CITY OF ALBUQUERQUE

**Re: The 14 West
Grading and Drainage Plan
Engineer's Stamp Date 1-15-2014 (K13/D050A)**

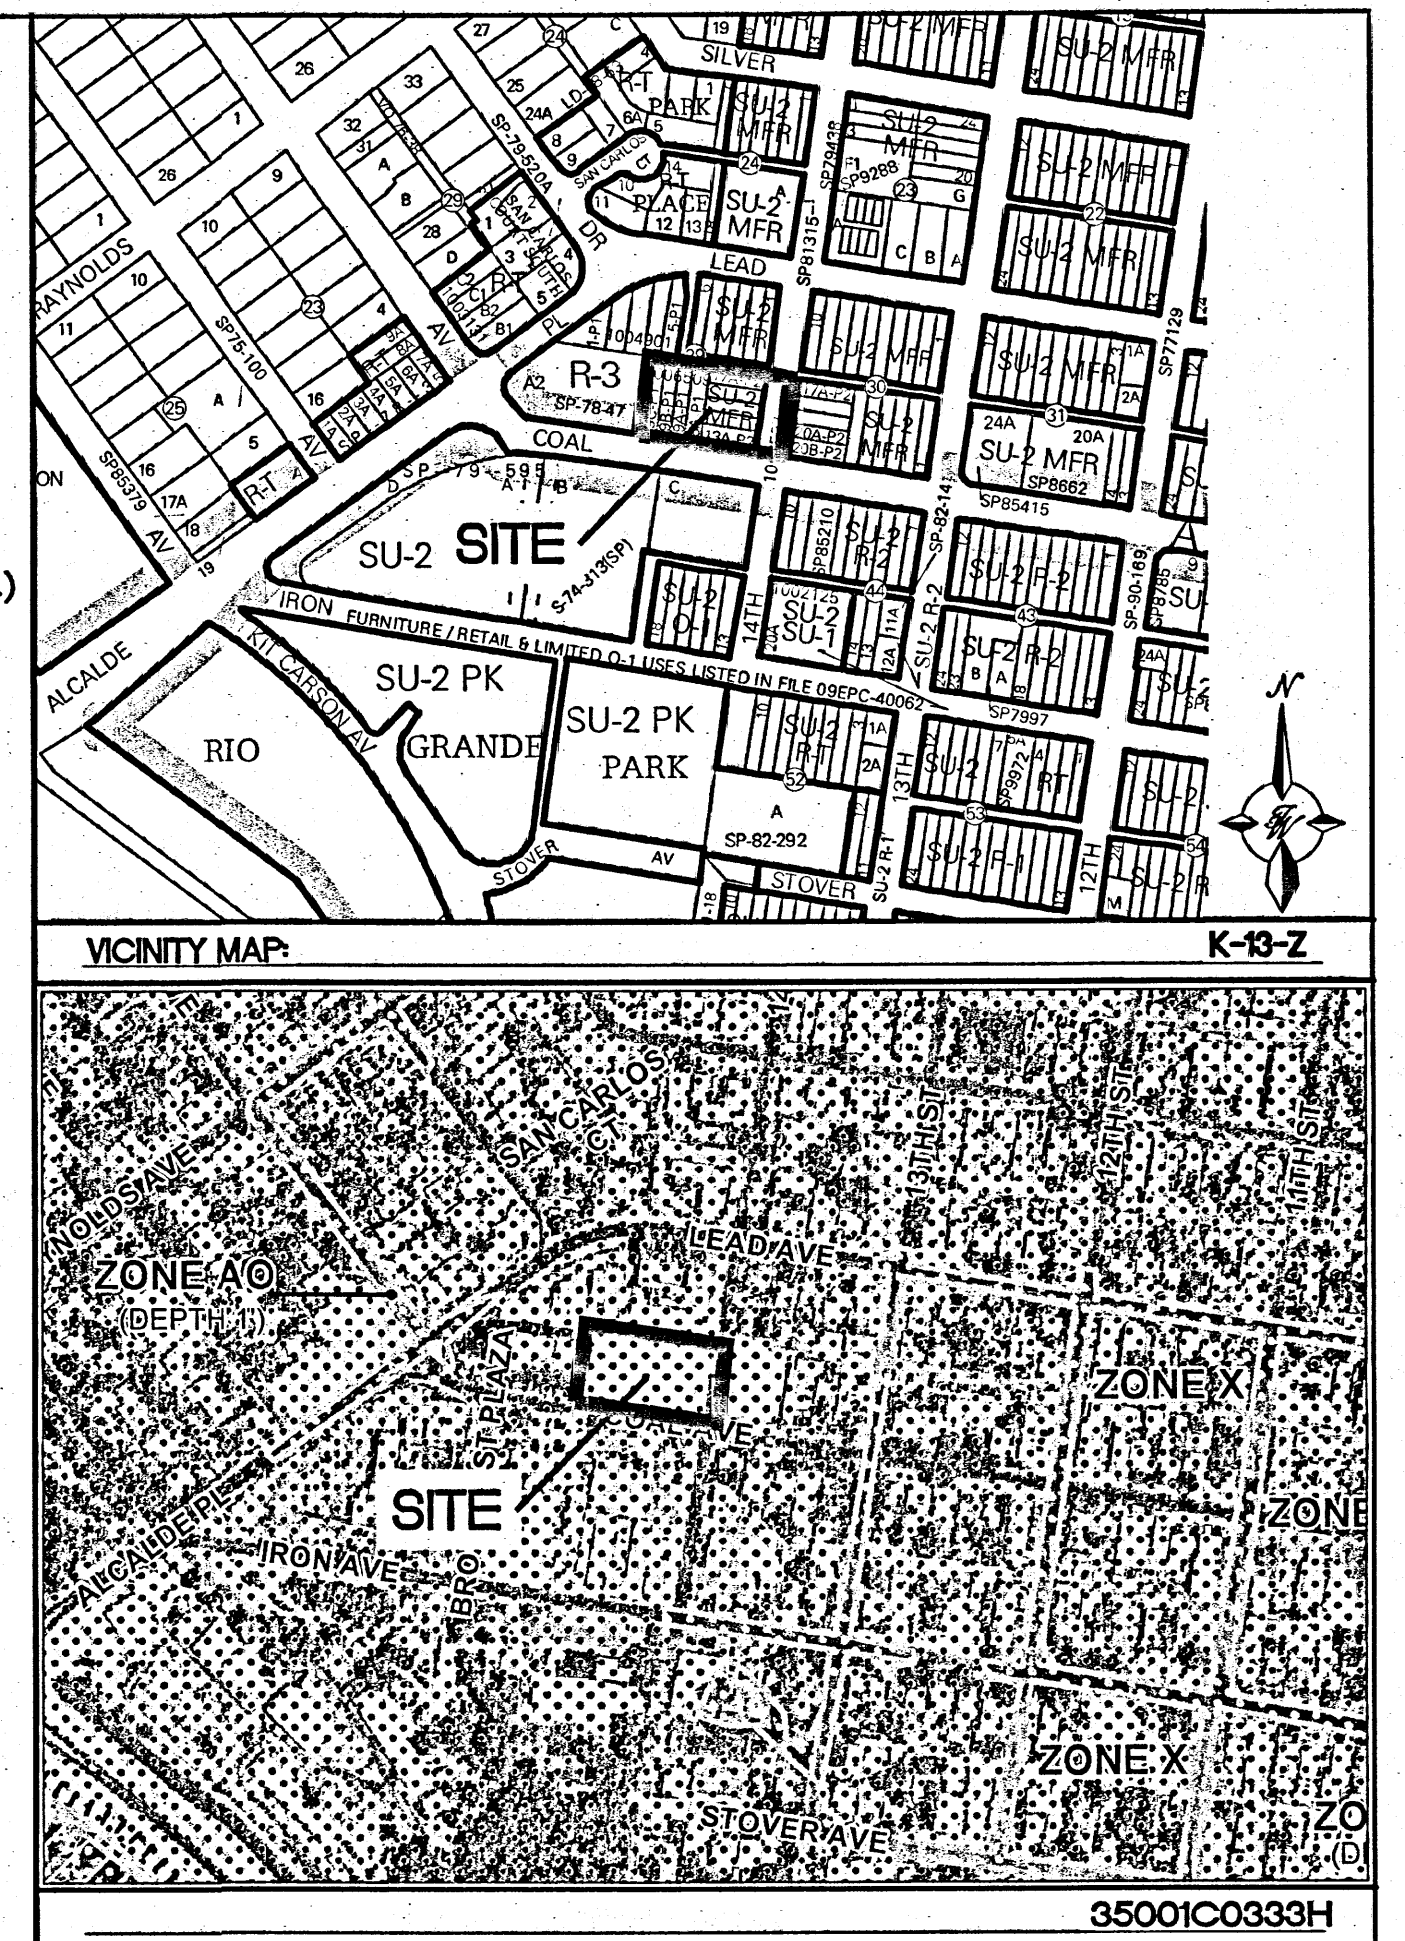
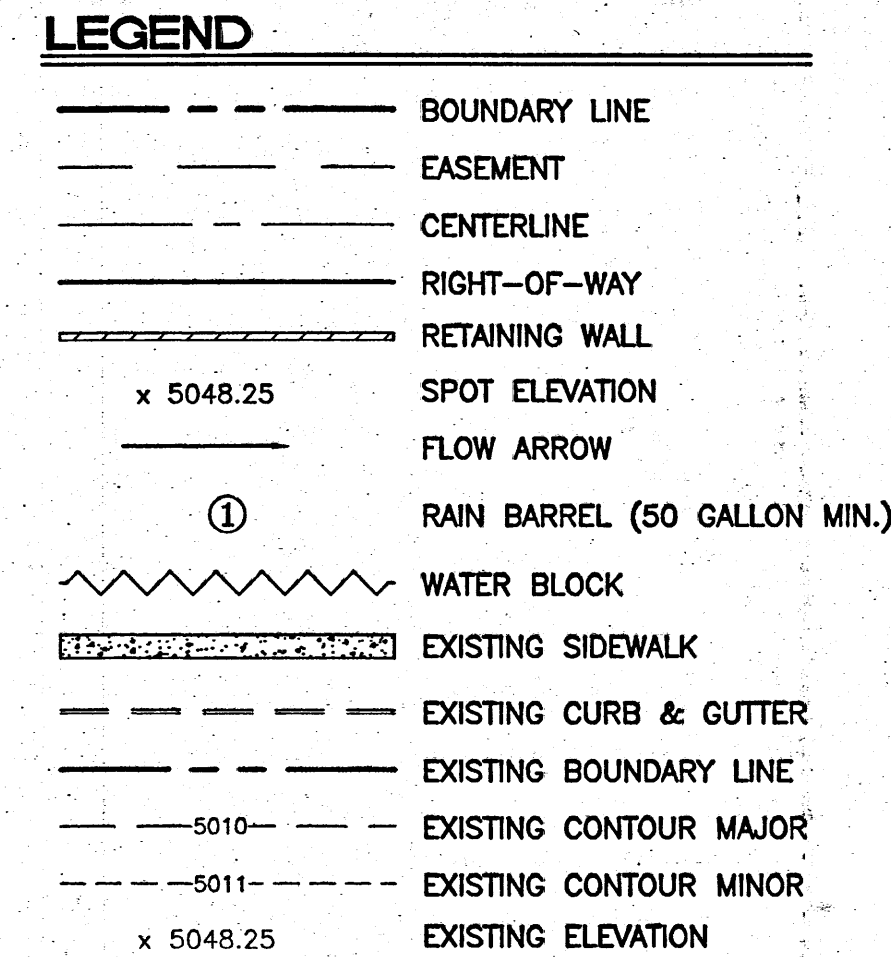
- Show more spot elevations along the alley to assure the runoff and gates/entrances are not being blocked with the proposed alley improvements. Show all the existing improvements.
